**COMMENTARY
ABNORMALS**

KENDALL GROVE, PINCHBECK

CP VIABILITY

MARCH 2026

Drawing 4.1 – Mitigation drawing

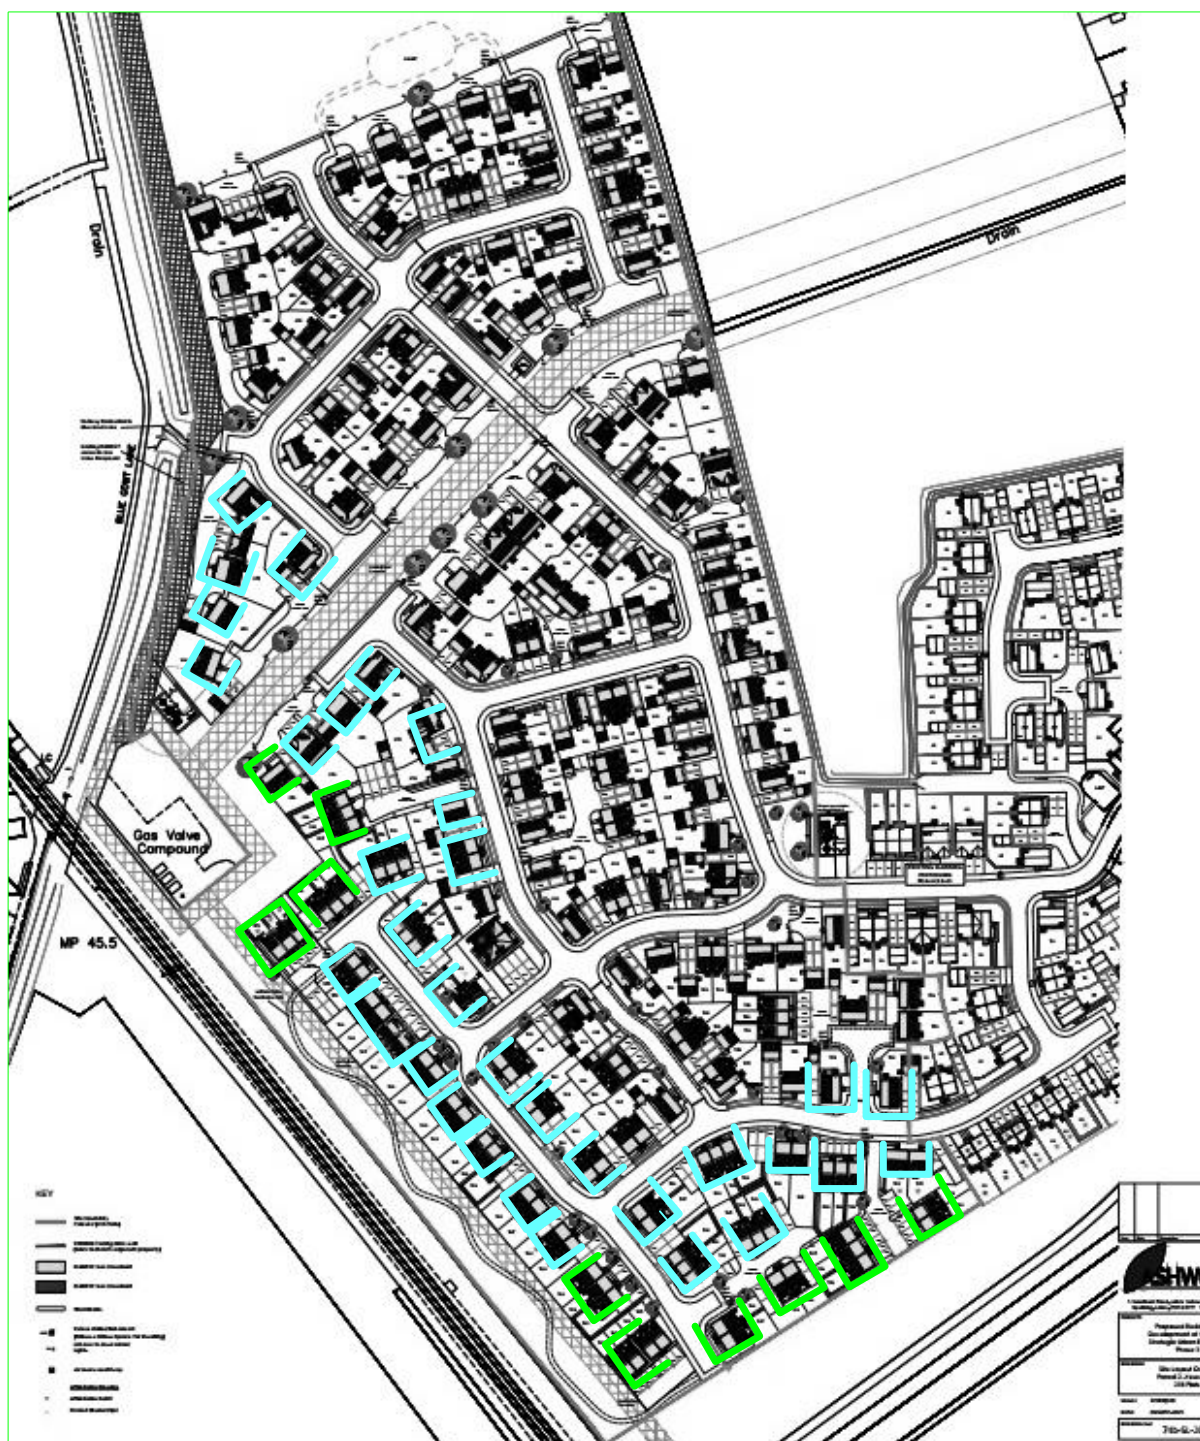
We consider the rate to be reasonable; however, we have measured 360 m using the Acoustic Measures Plan drawing and therefore calculate this cost to be £28,800.

Drawing file: H14-0083-26 / Yews Farm Phase 2 - LEAP.pdf

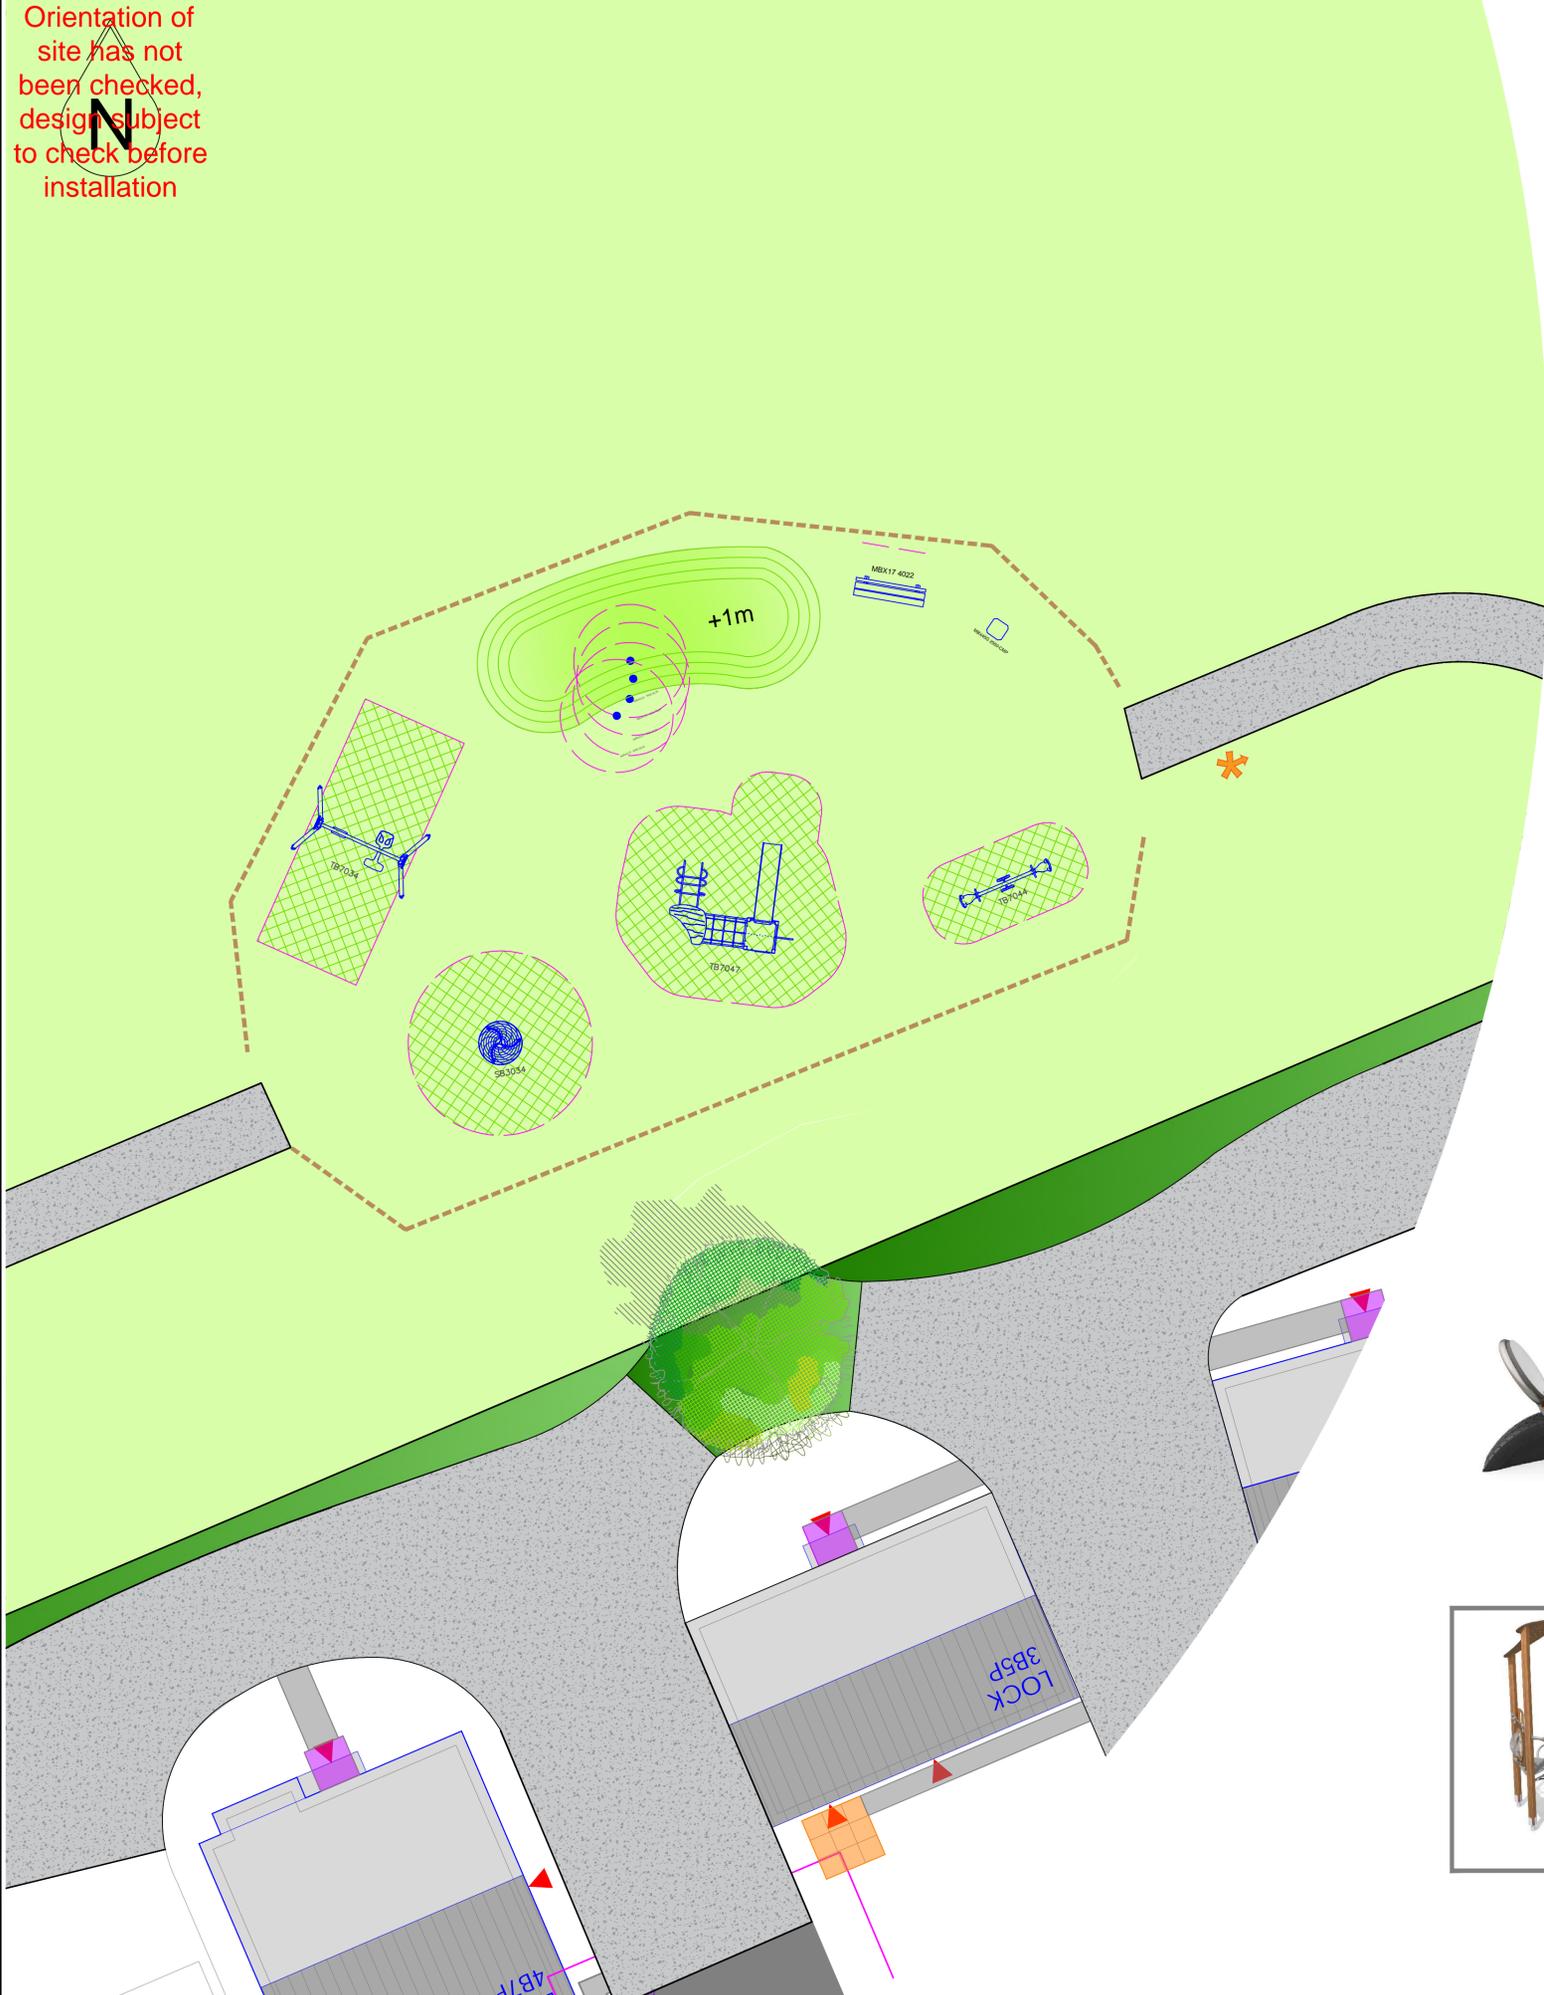
- 4.14 LEAP; £70,000
We note the LEAP is located in the north area of the site, but do not have sight of details. In our experience, we would consider a sum of £30,000 more than reasonable as an allowance to cover typical play and seating provision, especially considering that railing/fencing is included as a separate item below.

We would also note that the provision of a LEAP is not an uncommon planning requirement and as such should not be deemed an abnormal provision for a scheme of this size and value.
